Amendments

West Elevation

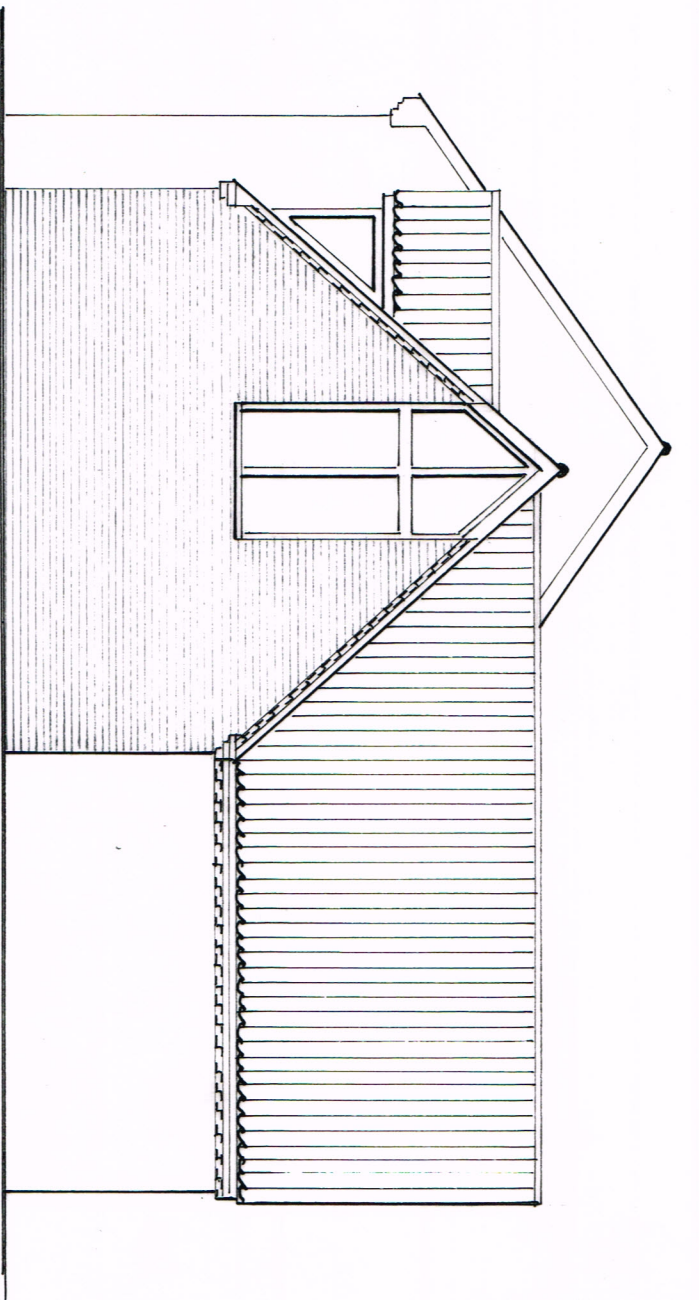
1. West elevation. Dormer back to original submission
2. South elevation. Revised window to en-suite
3. East elevation. Games room window revert to original application
4. Ground and first floor plans. Games room revert to original application
